**Consultation Response from KC,
Lead Local Flood Authority**

2026/90811 Trust Ford, St Andrew's Road, Huddersfield, HD1 6RJ

Extension of hardstanding to increase area of parking and used car display

Responding Ref: 1

CLIENT:	TrustFord
PROJECT:	TrustFord Huddersfield Proposed Extension of Car Parking Area St Andrew Road Huddersfield HD1 6RJ
TITLE:	Proposed Site Plan (Part) 1 of 2 & Existing Site Plan (Part)
SCALE:	1:200@A1
STATUS:	REV: E
JOB NUMBER:	AA05-01
DATE:	March 2025
DRAWN BY:

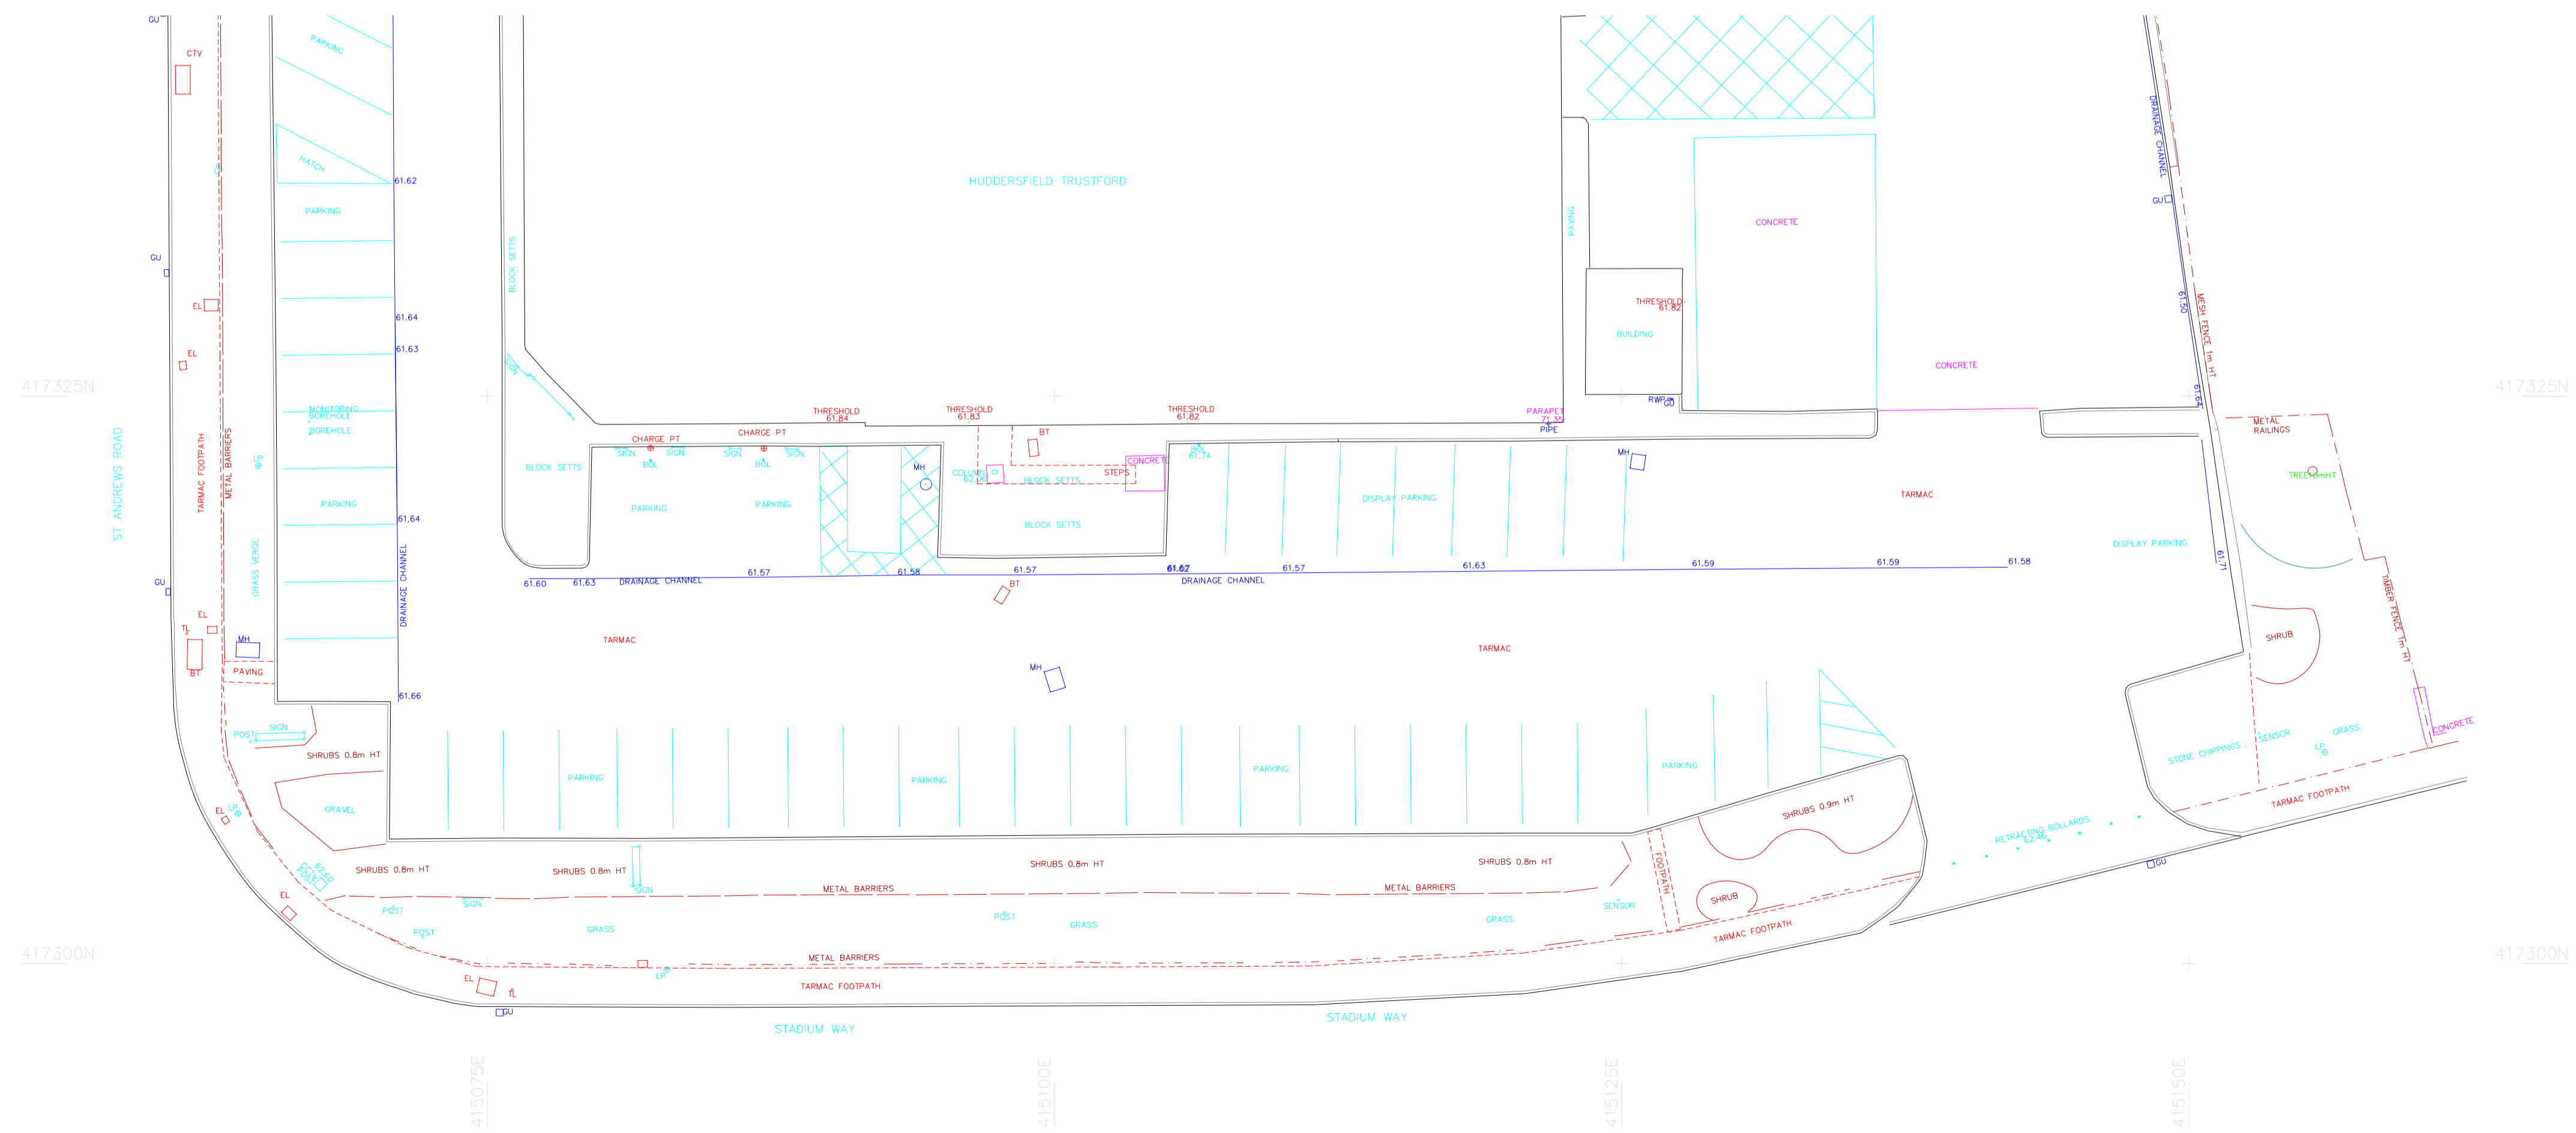
The development is within 20m of the river Colne; however, the proposed works does not appear to affect the river, and the site is fully within Flood Zone 1.

The increase in drained area due to the extension of the car parking onto land that is currently grassed is estimated as approx. 360m². However, it is deemed that this increase is not significant enough to increase flood risk and therefore attenuation of surface water run-off from the site is not required

Kirklees Flood Management and Drainage as the Lead Local Flood Authority, SUPPORTS this application and has no recommended drainage conditions.
